Queens Park Precinct Executive Committee

16 July 2020

Comments on Moriah College's Response to Submissions (RtS)(SSD-10352)

1 ELEVATION Eastern Elevation

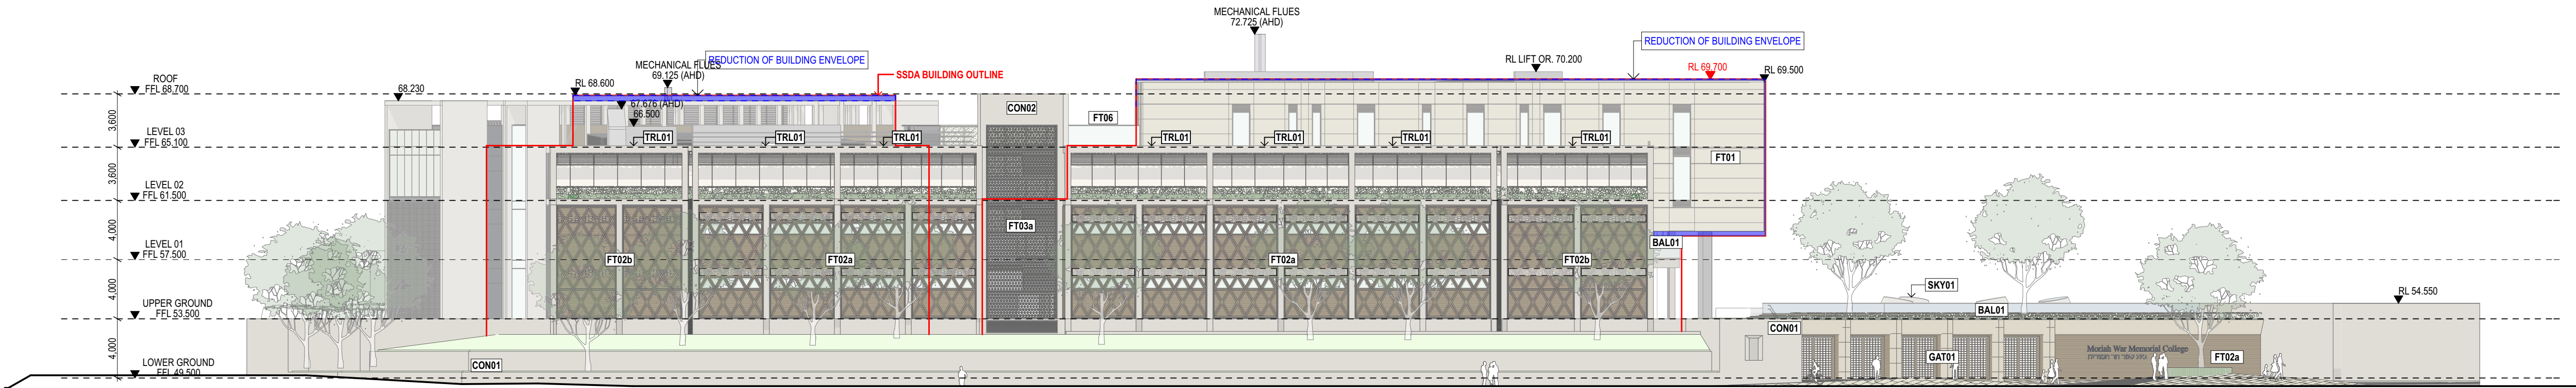
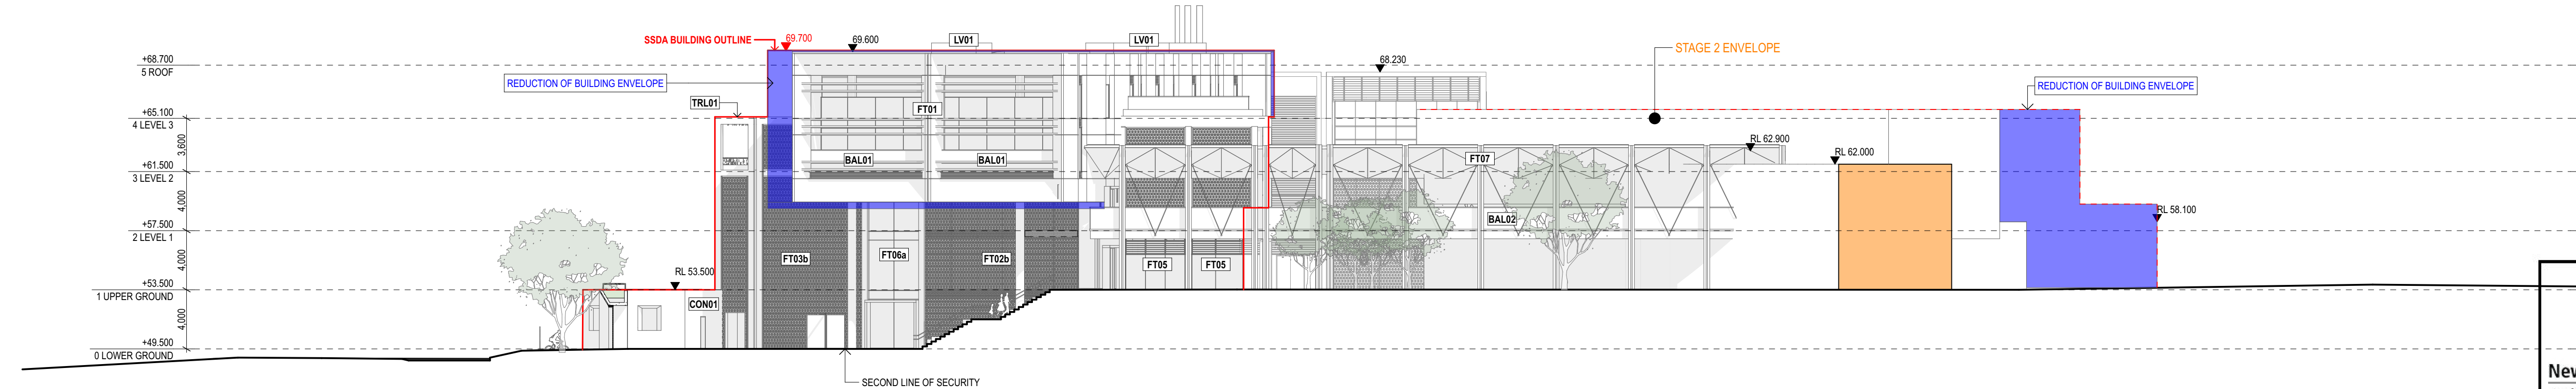
While the upper level being recessed slightly from Baronga Ave is a minor improvement, the scale of the building is still excessive and totally inappropriate.

The height adjustments to the northern and southern wings are negligible and still way over the height limit of 8.5m.

We still believe that this huge structure is not the least bit compatible with its location and will be visually jarring when viewed from Queens Park and Baronga Ave.
